Harnett County Government Complex
307 W. Cornelius Harnett Boulevard
Lillington, NC 27546

**RE: Existing Septic System Inspection BRES #1810-0013
113 Circle Island Drive**

SITE PLAN APPROVAL

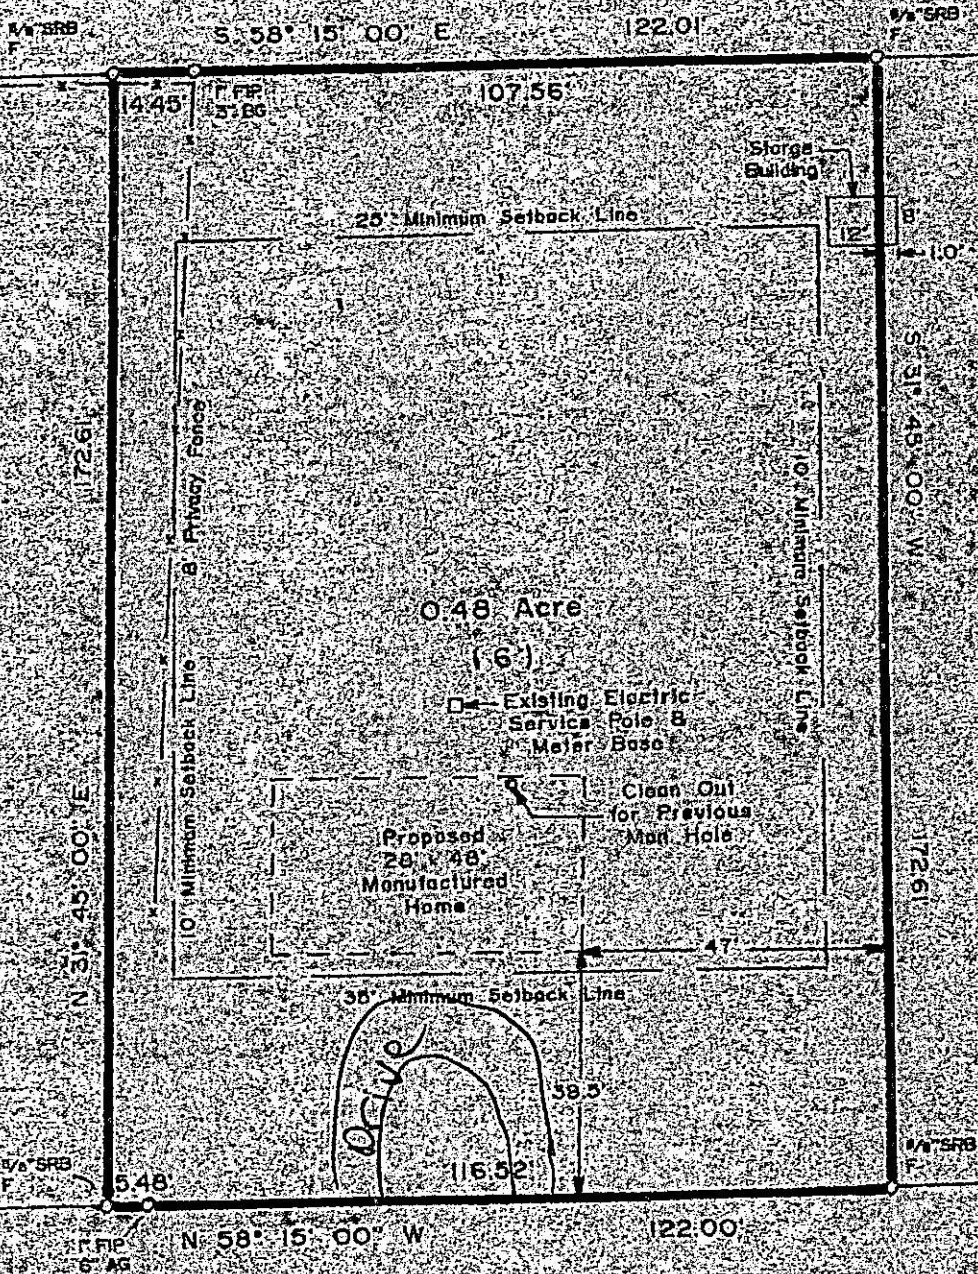
Doublewide mobile home (DWMH) placement denied. Revision Required. DWMH shall be a minimum of 5 feet from septic tank. DWMH shall be shifted back off septic tank to be located appropriately, where former mobile home was located. The circle driveway disapproved due to septic lines located in front yard. Driveway shall follow existing path along the right side. Tank inspection not complete. Handles broken off lids. Lids cracked. Septic lids shall be replaced and re-inspected. Unable to inspect sanitary tee. Distribution box full of soil and debris. Distribution box shall be cleaned out and/or replacement may be required. Call Environmental Health with questions, comments, concerns. Revise paperwork and advise when to respect.
